CITY OF ALBUQUERQUE

March 12, 2025

**Re: West Mesa Ridge
Traffic Impact Study(J11D048)**
Engineer's Stamp 2-25-25
Via email: clay.koontz@stantec.com and ABQ-PLAN

The subject Traffic Impact Study (Study) draft received on February 25, 2025 , has been reviewed by the City of Albuquerque Planning Development Transportation Section and provides the following comments.

TCL1.0

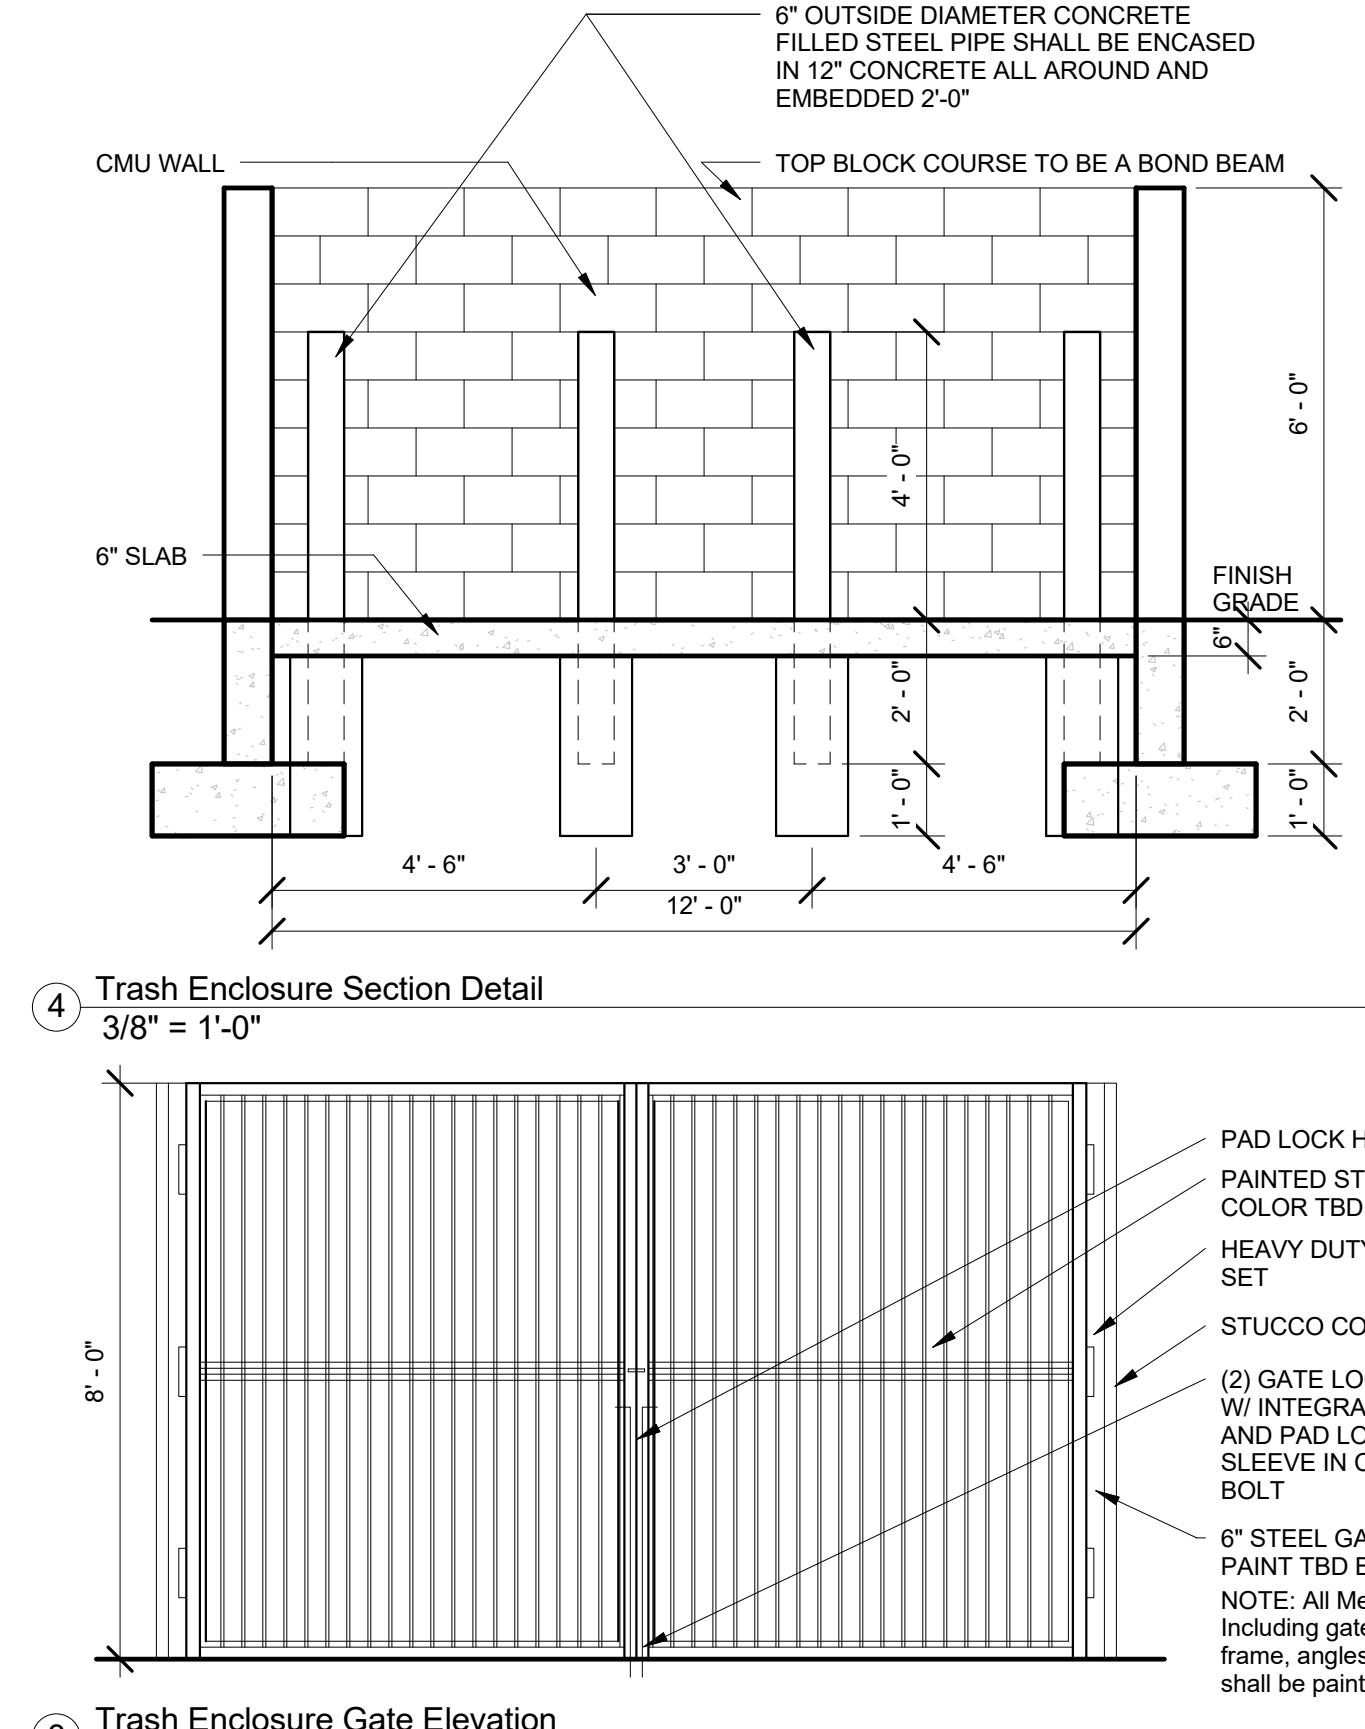
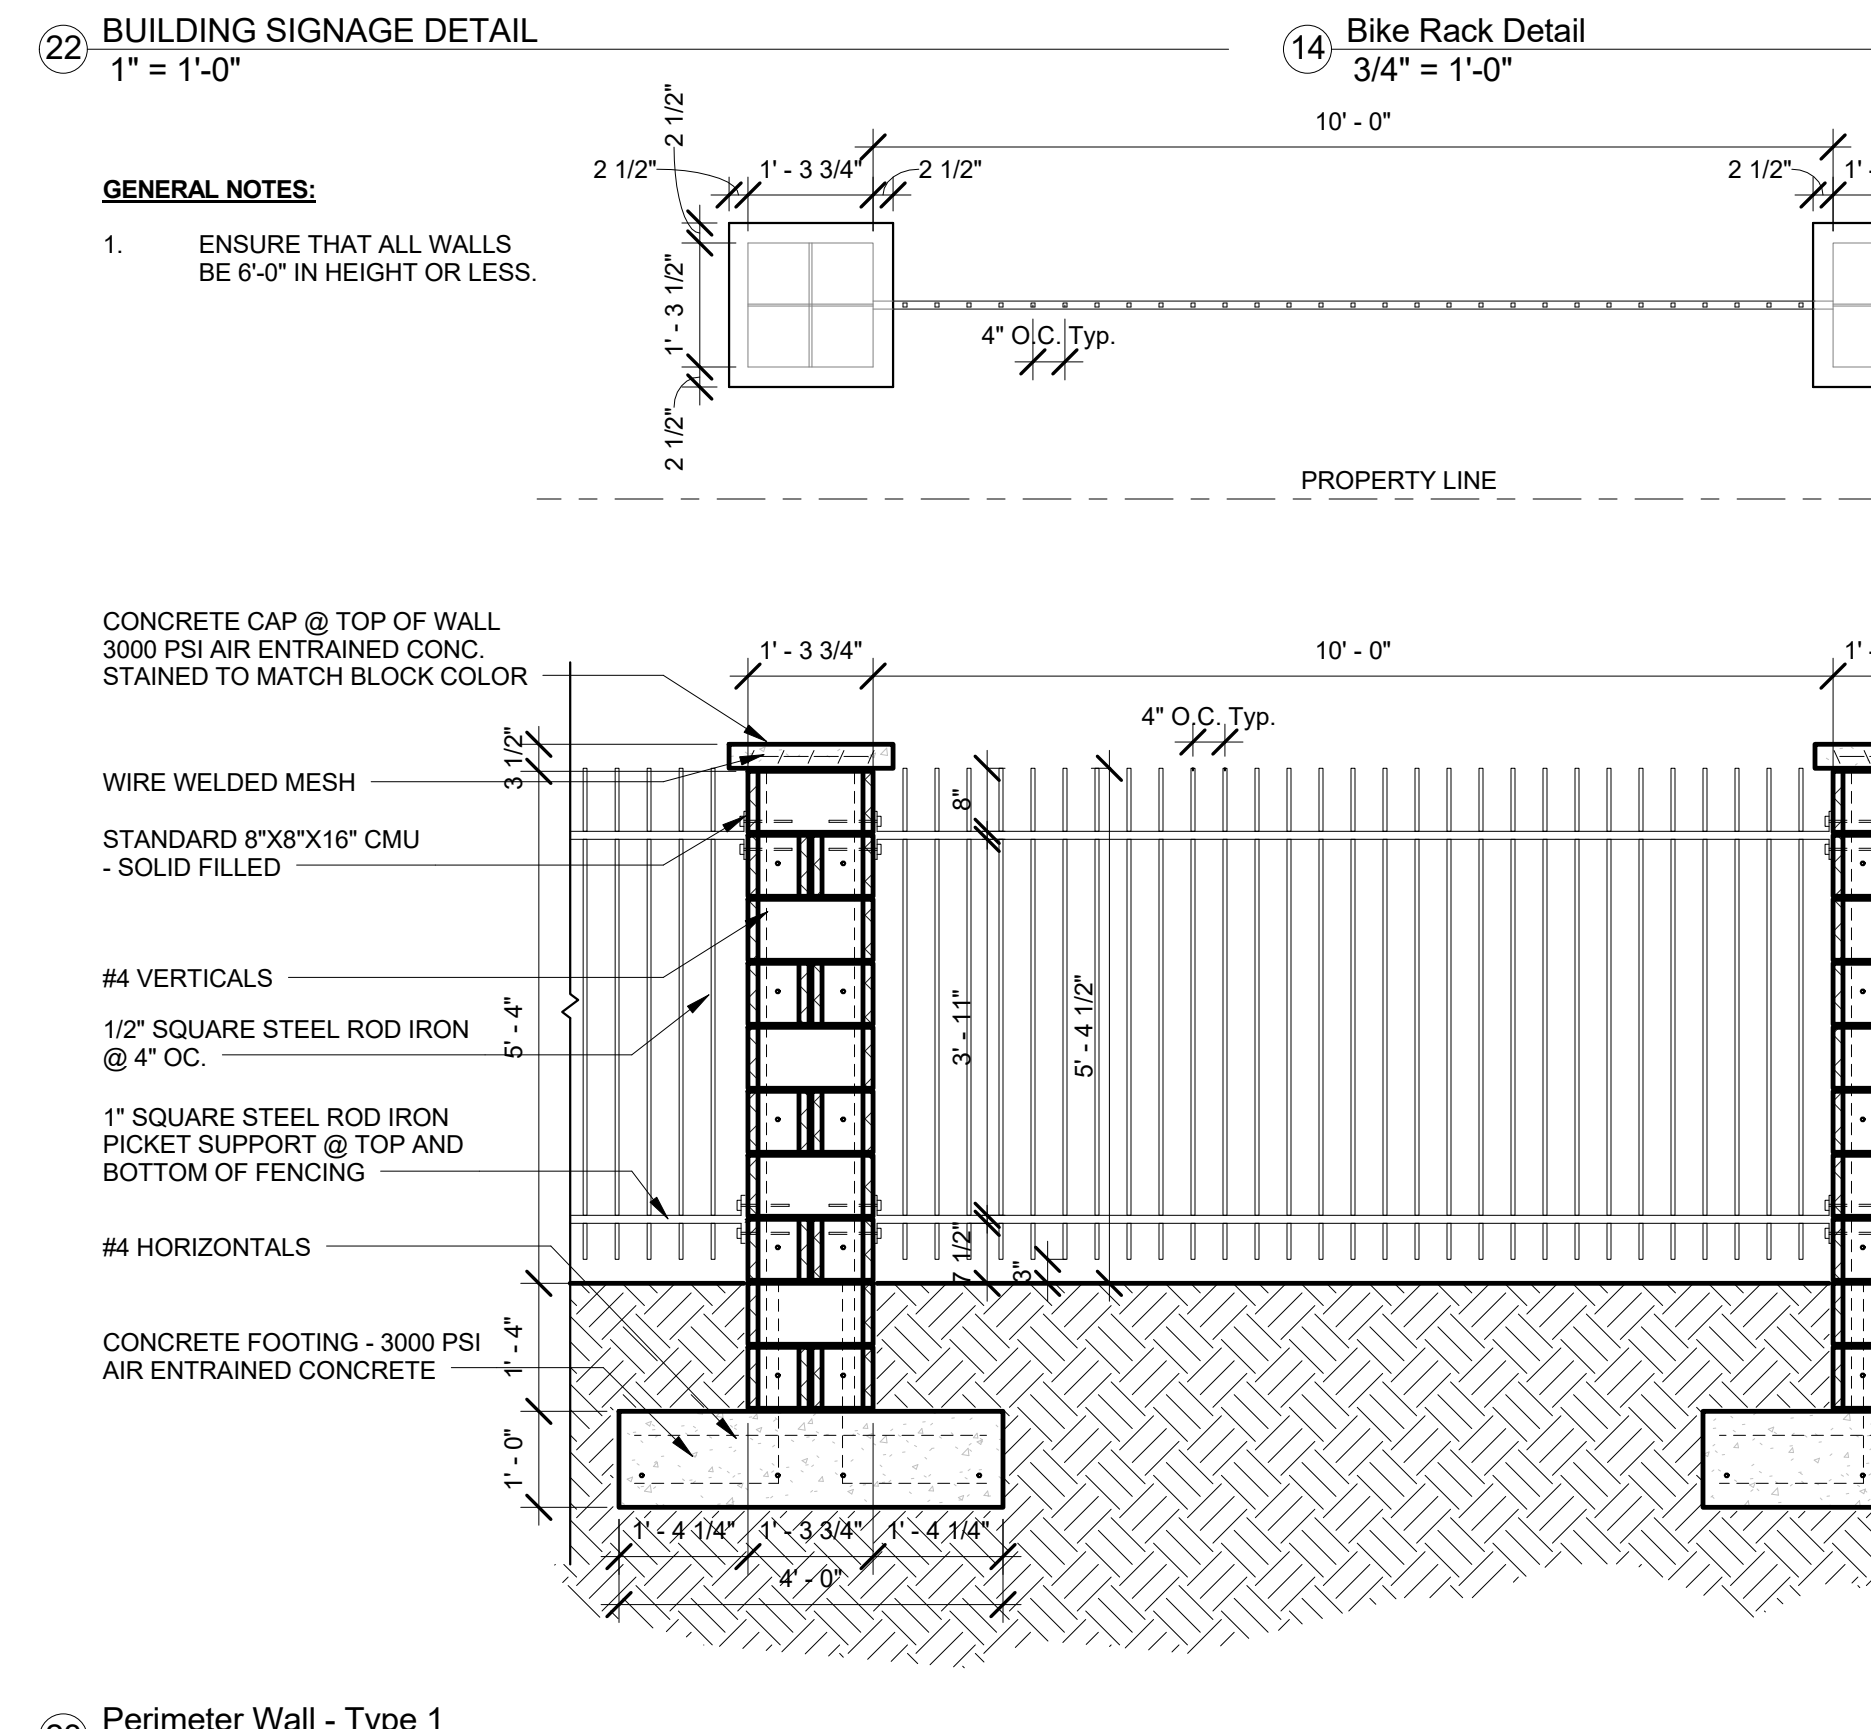
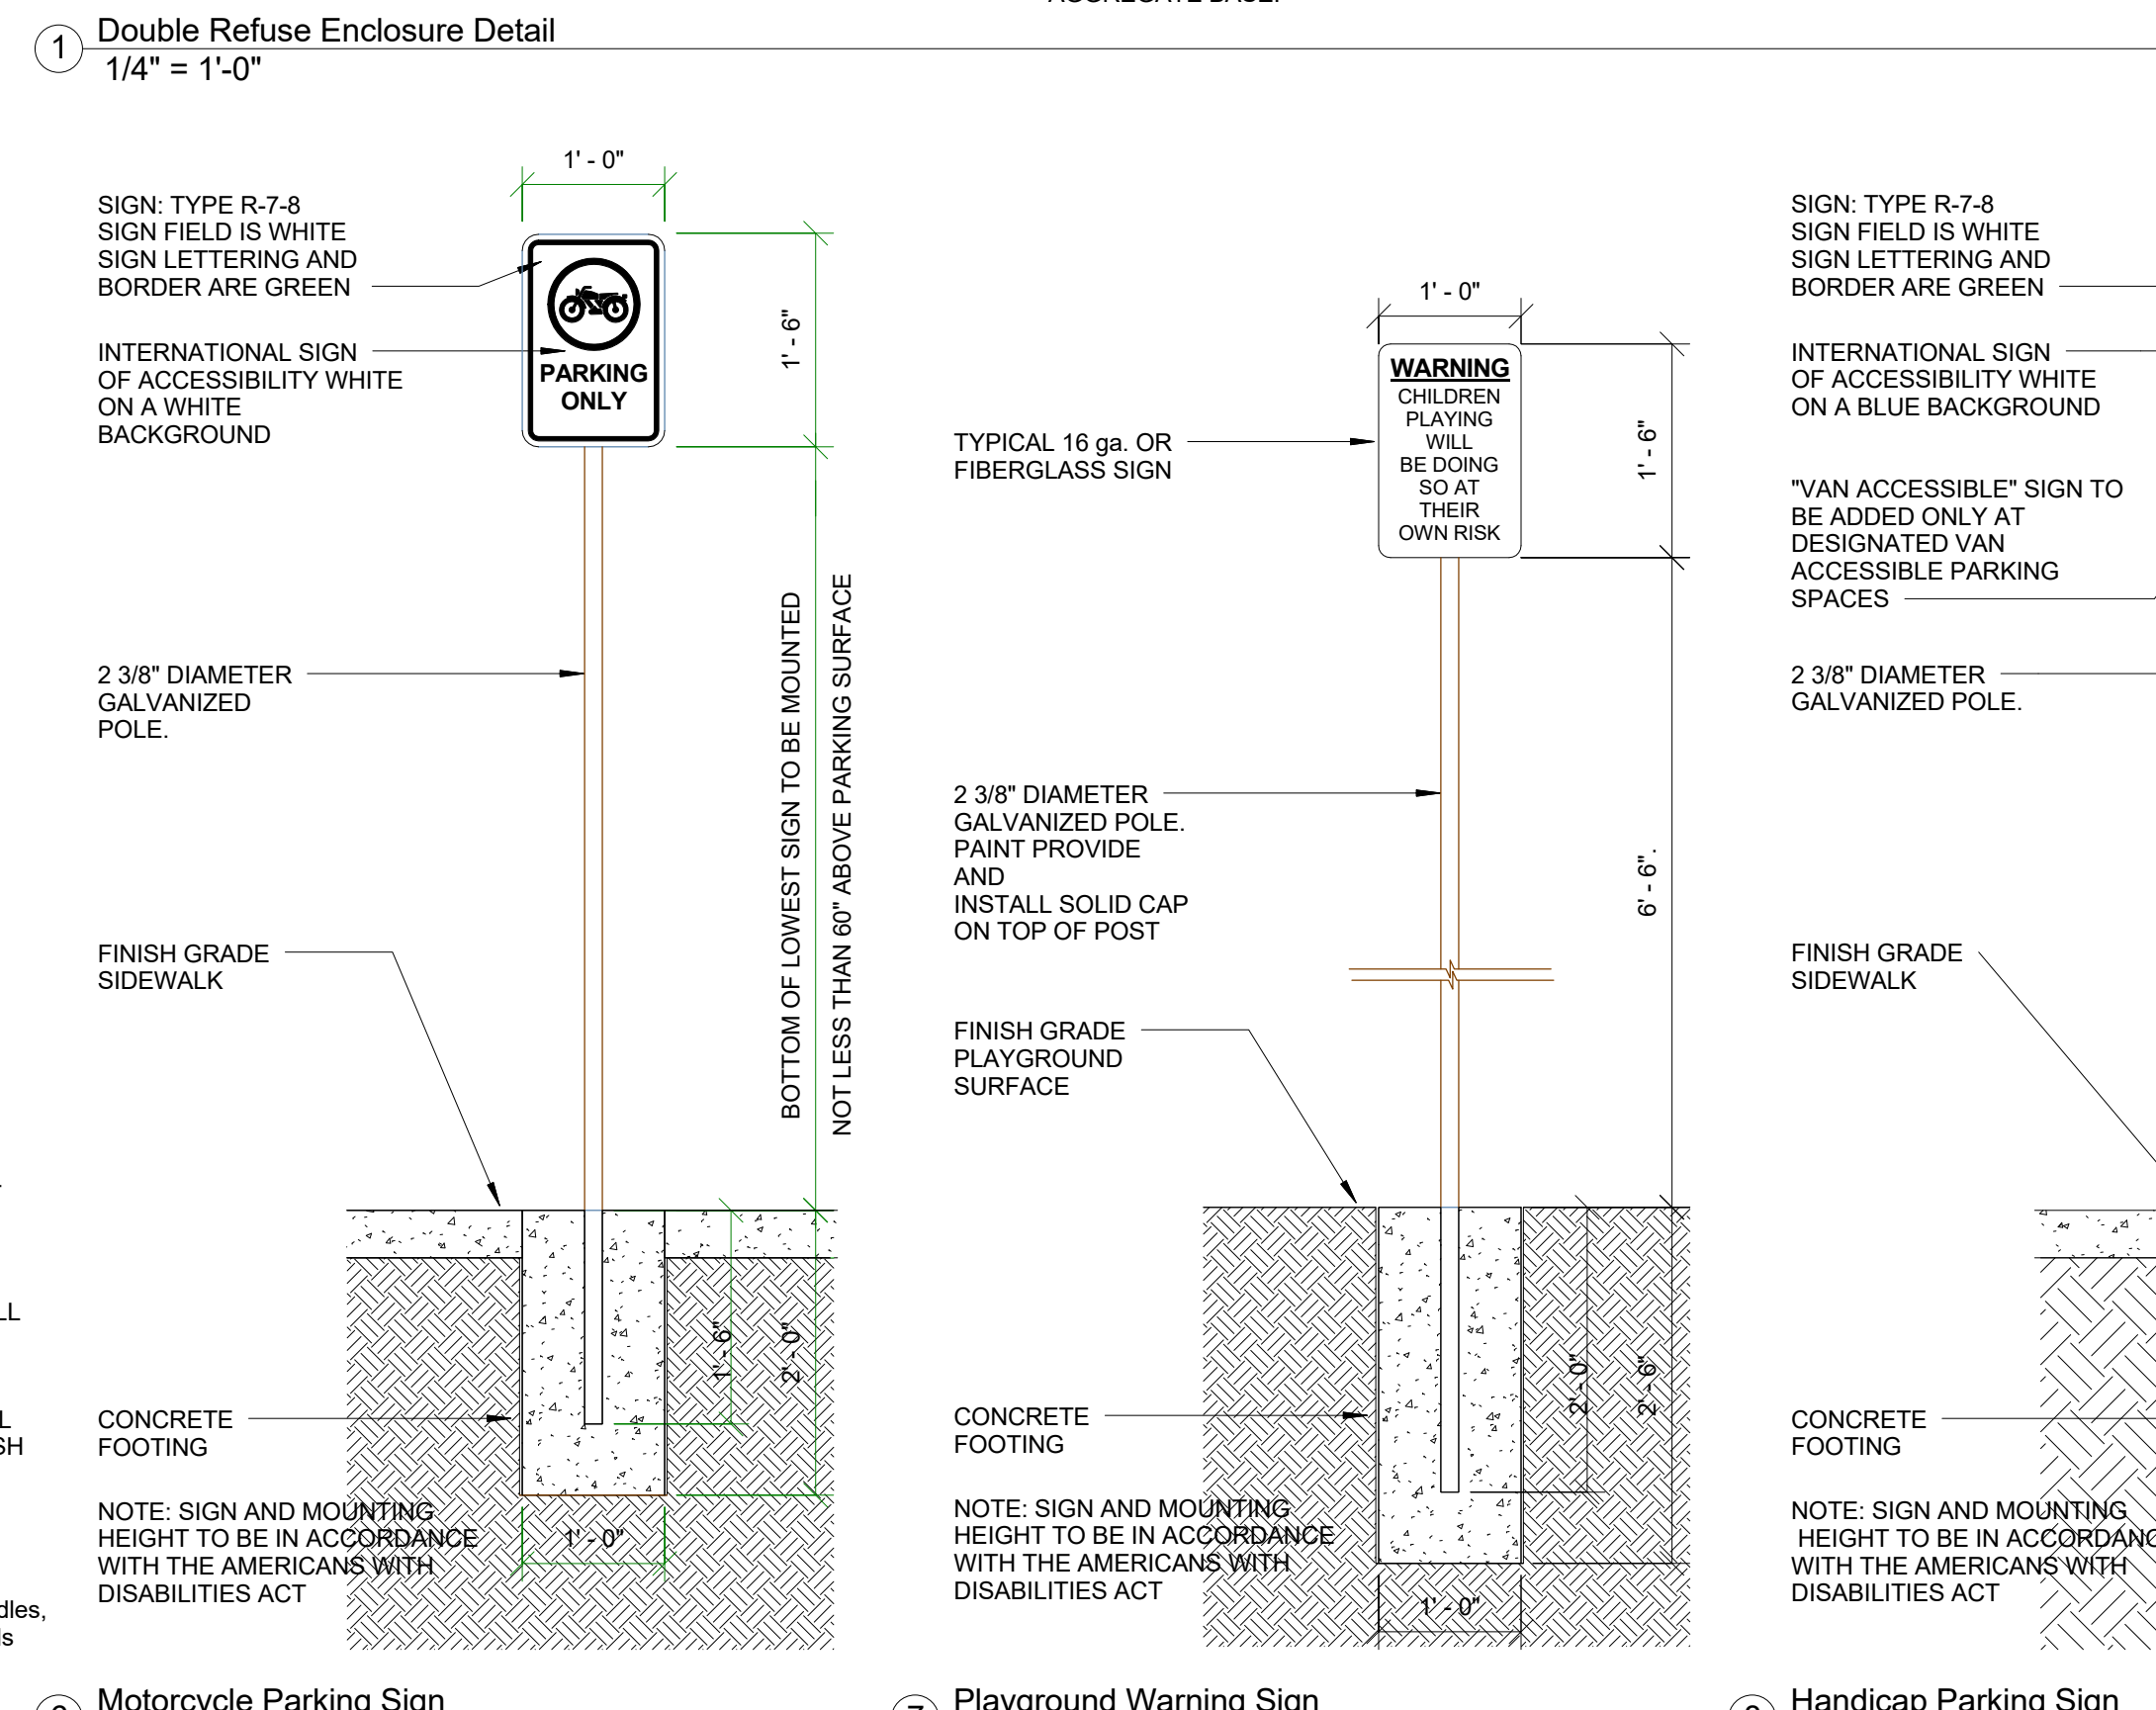
- b. Adding a crosswalk and signage should improve pedestrian safety at 64th and Fortuna Rd.
 - c. The walking distance across the Fortuna Rd entrance should be shorter or include a pedestrian refuge.

- d. Reduce radii at all entrances to 15'. This will shorten pedestrian paths and may require a slow drivers.
